Environmental Health Consultation Response

Detail: Planning request 3/2017/1002

Address:	44-46 King street Clitheroe BB7 2EU		
Application Ref:	37794	Case Officer:	
Response Ref:	/ENV/01	Issue Date:

Drawing Title
 Proposed First Floor Plan

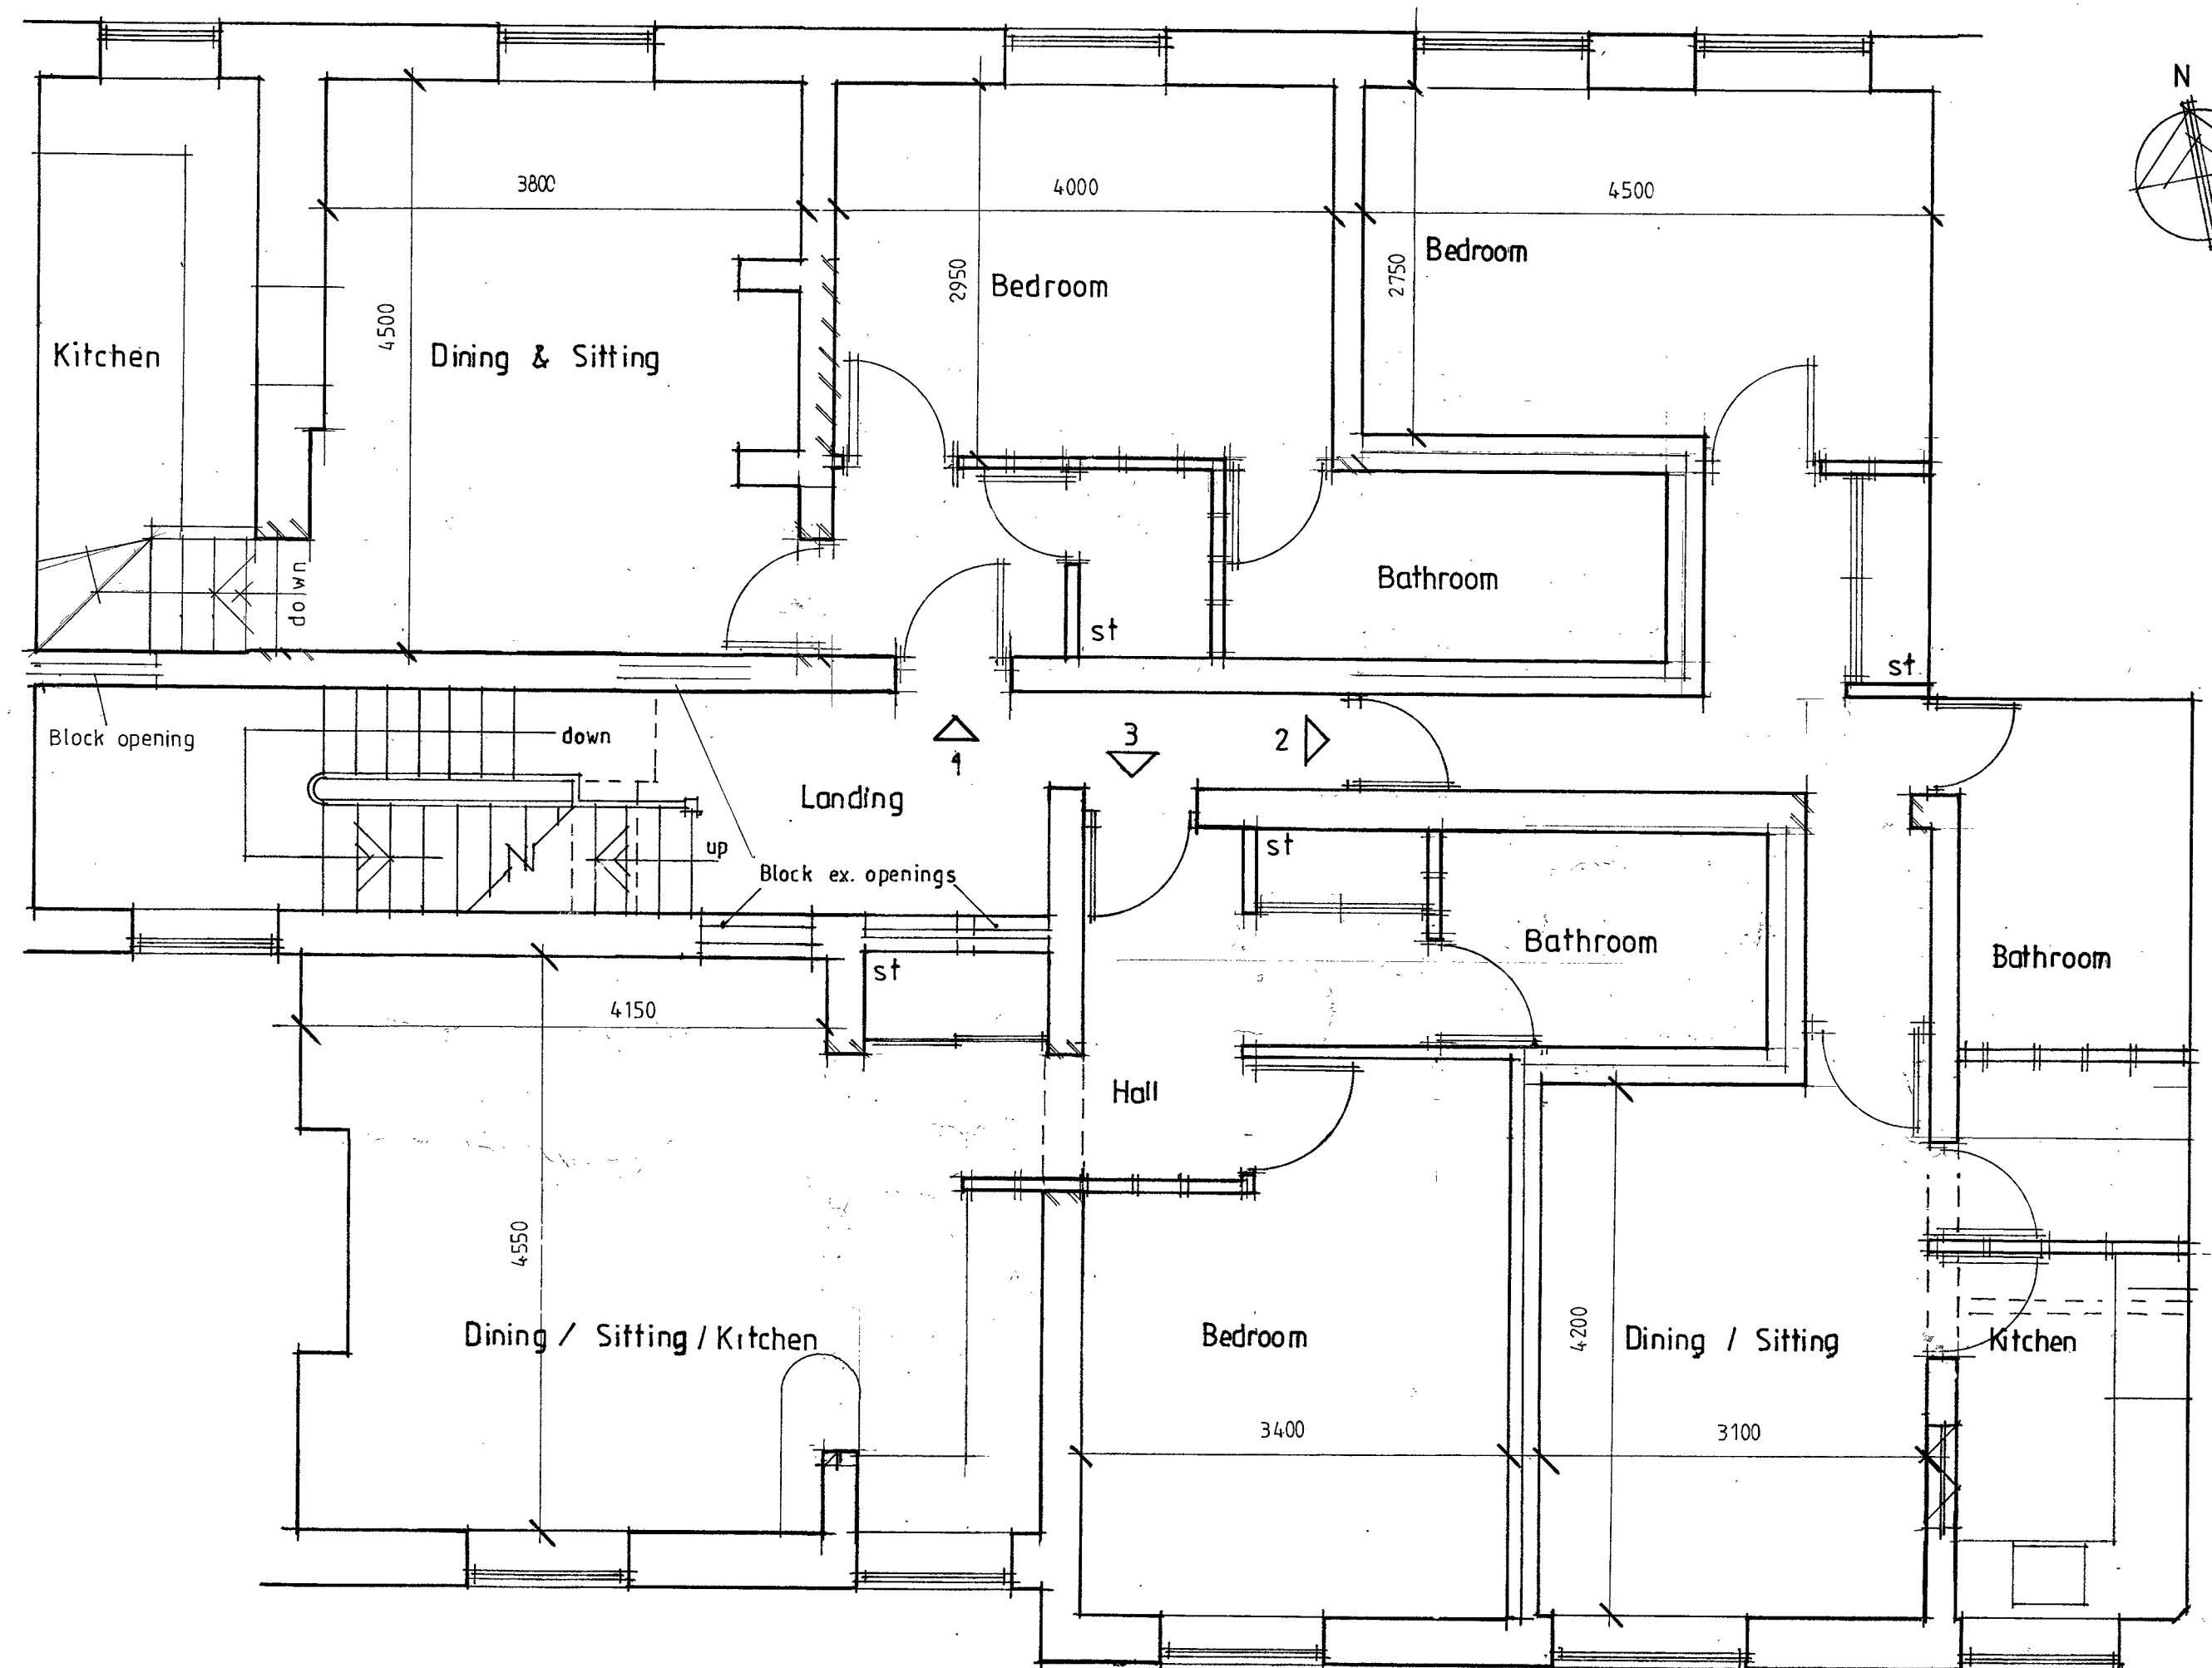
2.1	The application describes internal structural changes will only require internal stud partition wall changes. Sufficient insulation should be considered to provide sufficient noise insulation between the apartments and the retail outlet.

2.5	Conditions are suggested for the introduction of suitable noise insulation between each apartment and between the retail area and the self-contained apartments.

Proposed Plans

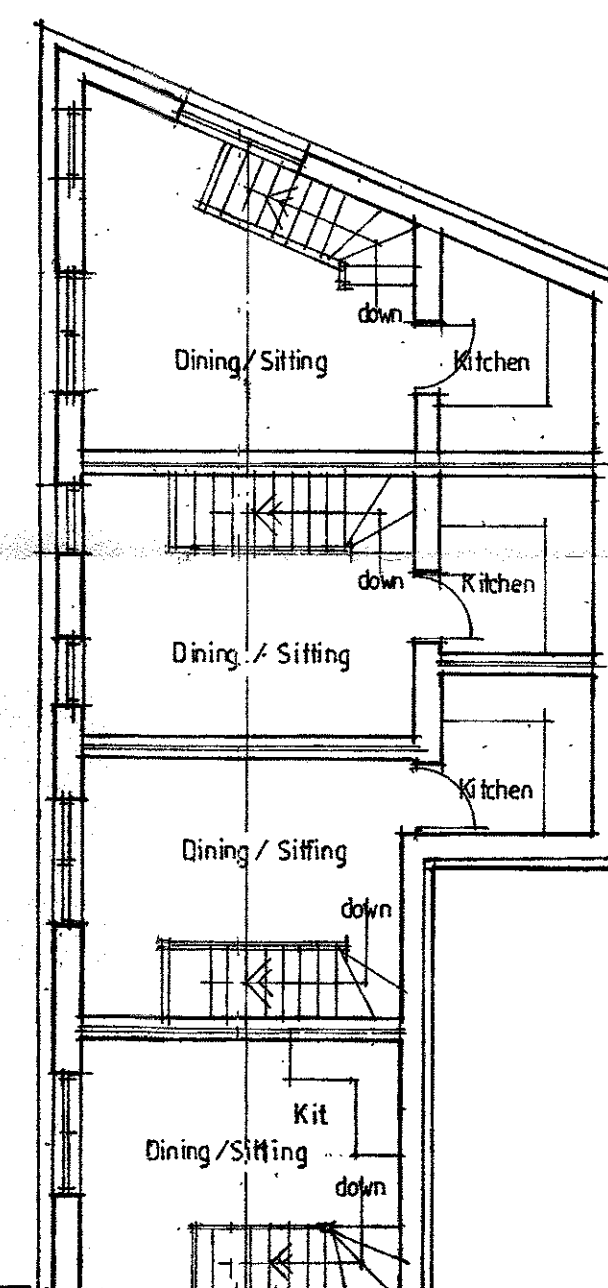
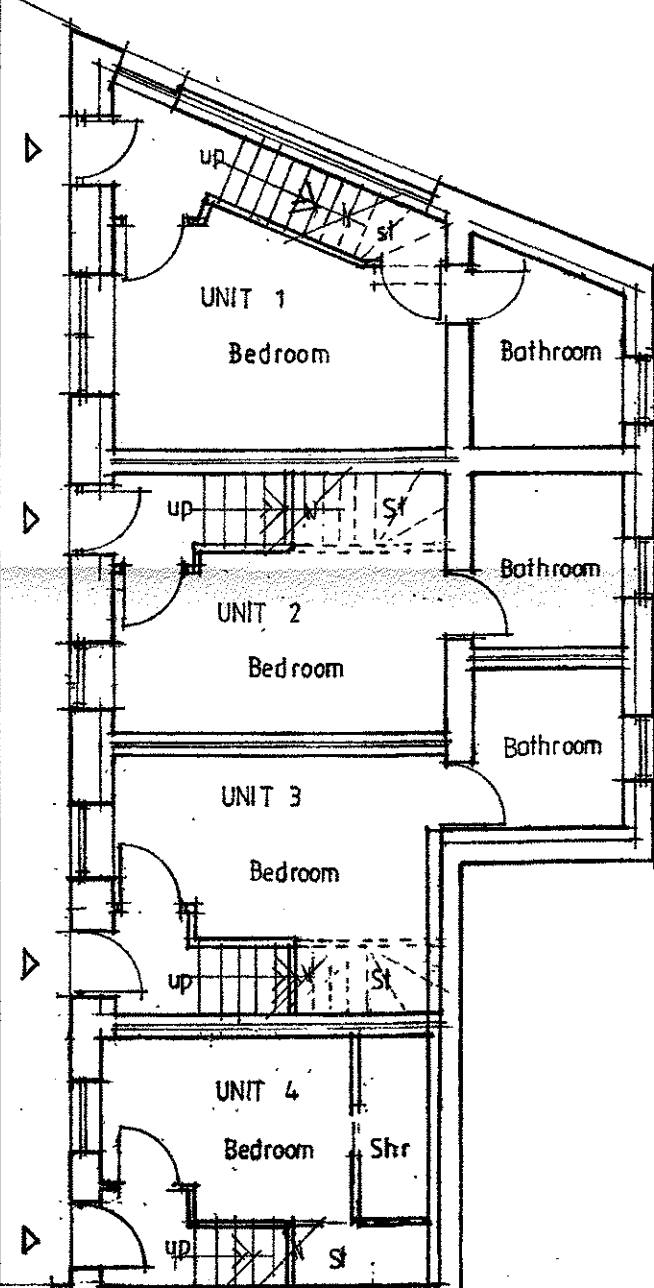
2.2	There is little information regarding the refuse storage. Suitable bin storage should be introduced to provide sufficient storage for all apartments and the retails. This could be individual storage for each apartment or larger bins for communal use. Larger containers may be required for trade waste removal for the retail area, further advice is suggested from the council trade waste officer for the most appropriate option.
Conclusions/Suggested Conditions

2.6	Suitable bins storage for apartments and the retails area required.
